Planning reference:-
R/152/13

Pine Lodge
7 Westmead
Willowhayne, (Rustington or East Preston)
West Sussex
BN16 2SL

With reference to the proposed building application for Mr & Mrs K Drew of 8 Westmead East Preston.

West Elevation

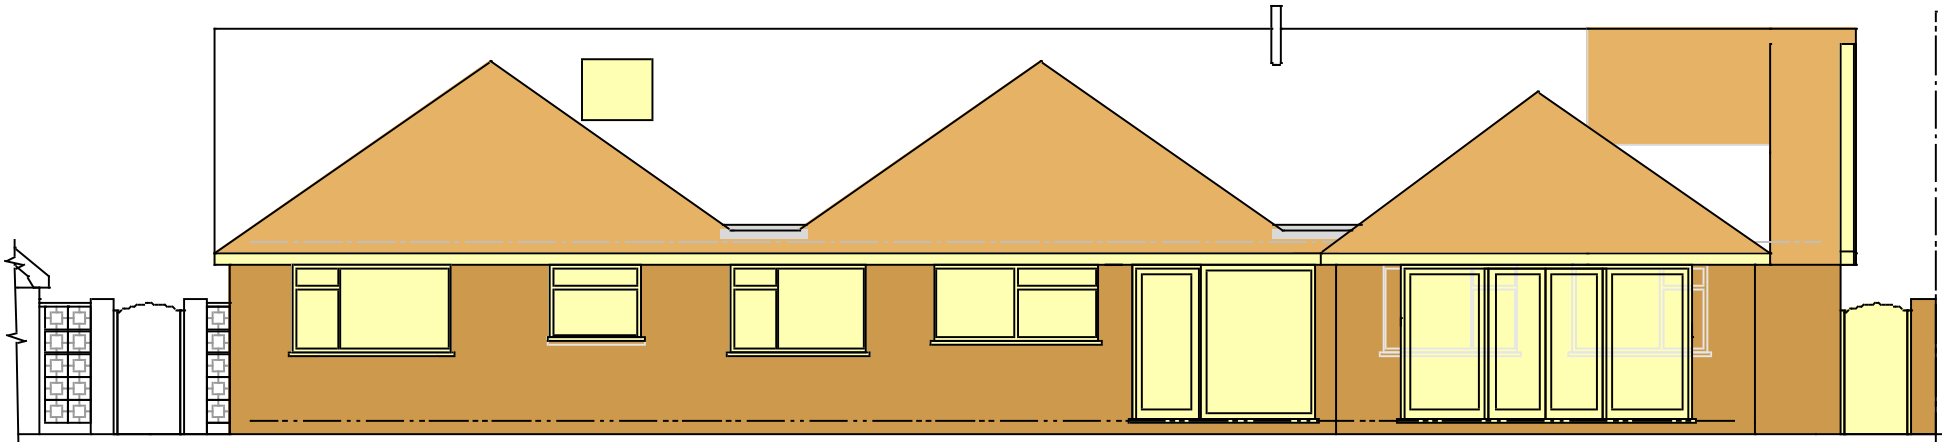
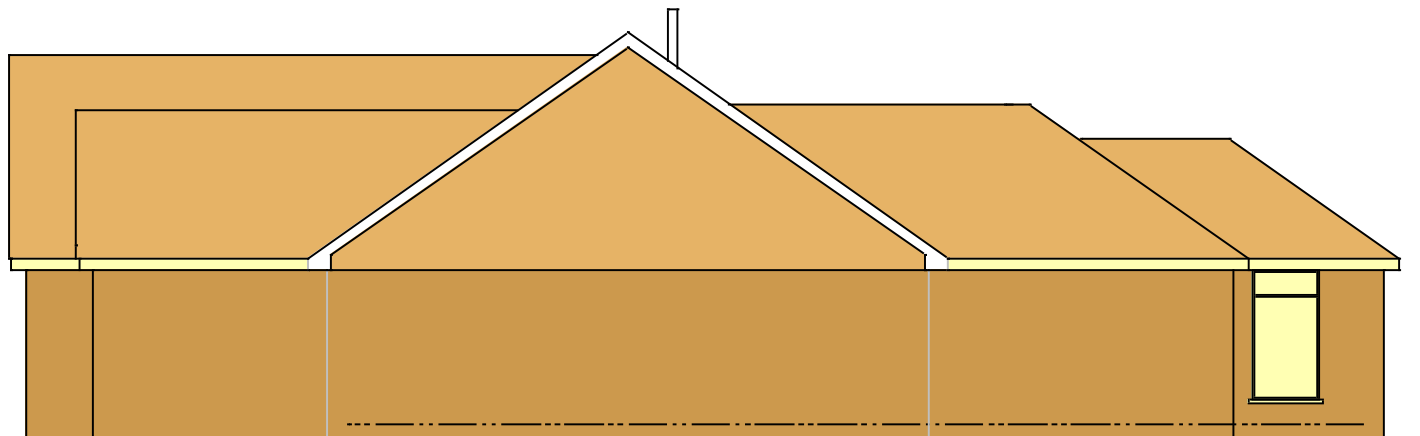
The pitched roofs at the West side of their property, thus being the East side of my property, will be very intrusive to:-

- ① Too near to my boundary fence line.
- ② my top floor bedroom, and 2 bathroom windows
- ③ also my lower bedroom and bathroom windows.
